Add COM-2222

RE: James Irwin Charter School
Traffic Technical Memorandum
El Paso County, Colorado
LSC #224370

Proposed Laneage - New North Access

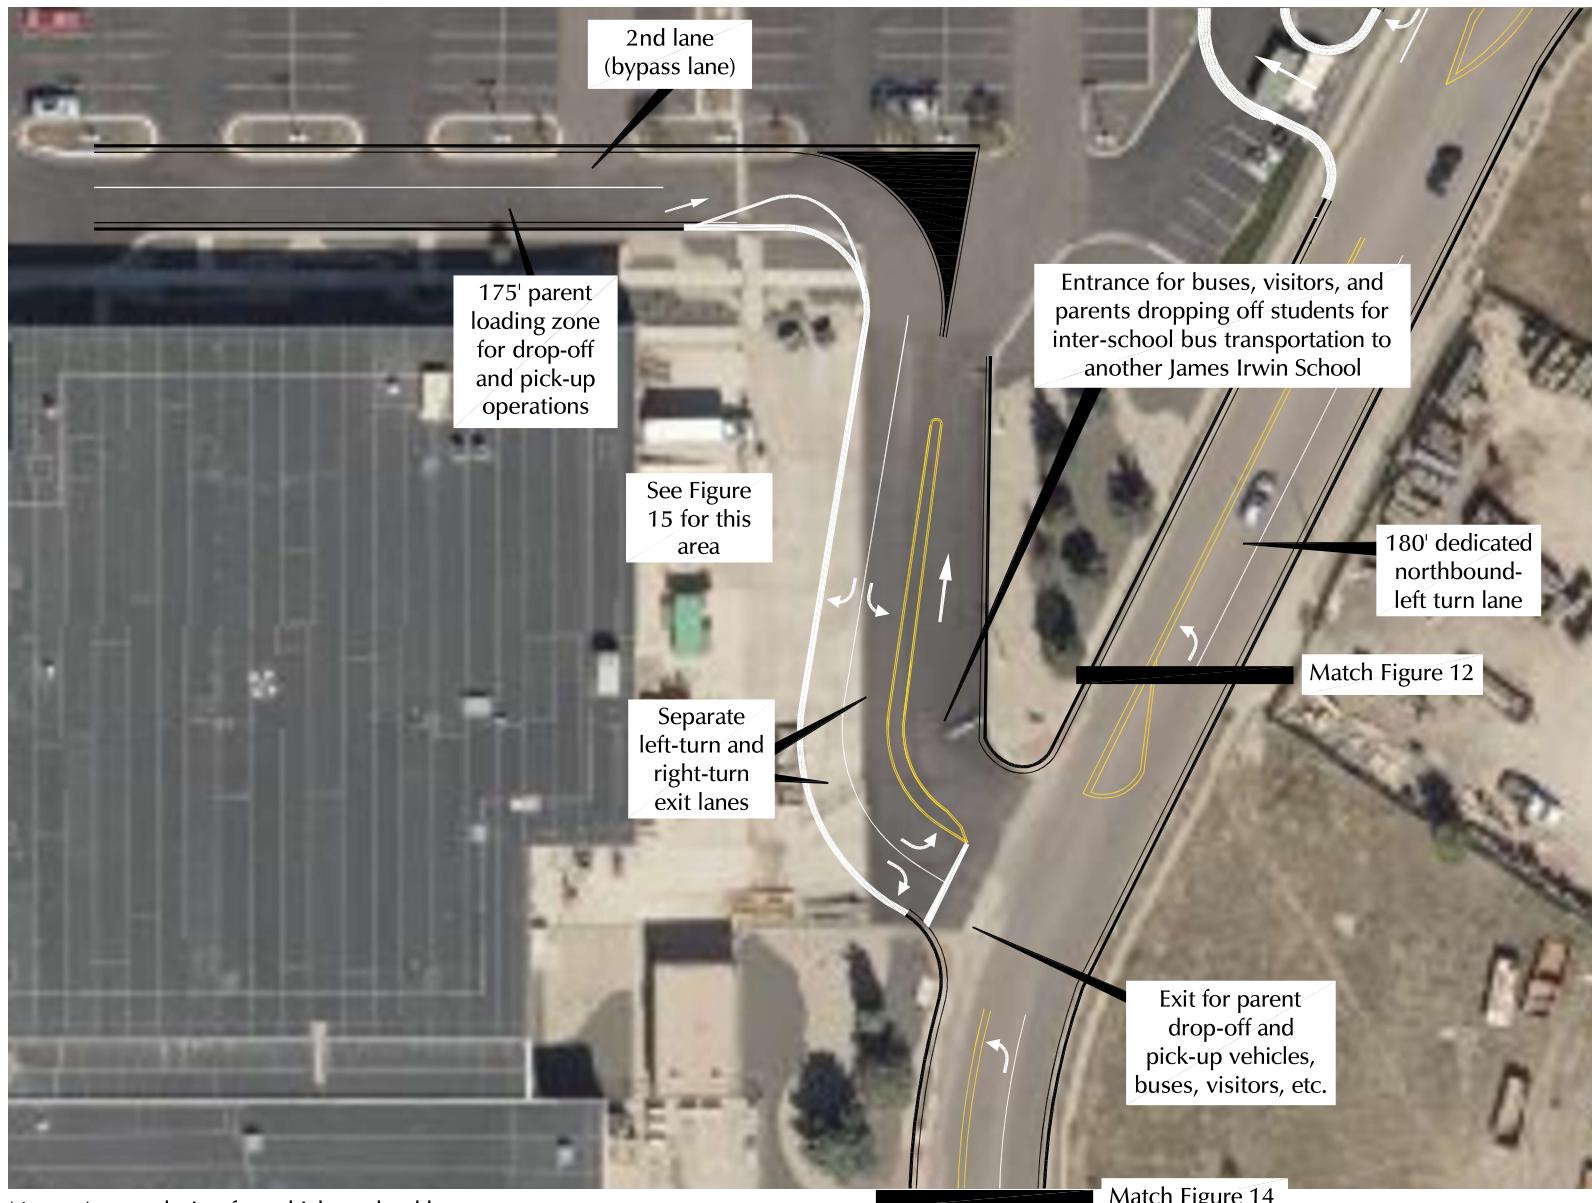
Configuration of access points and signing and striping will be required with this application. Provide recommendations in the next submittal.
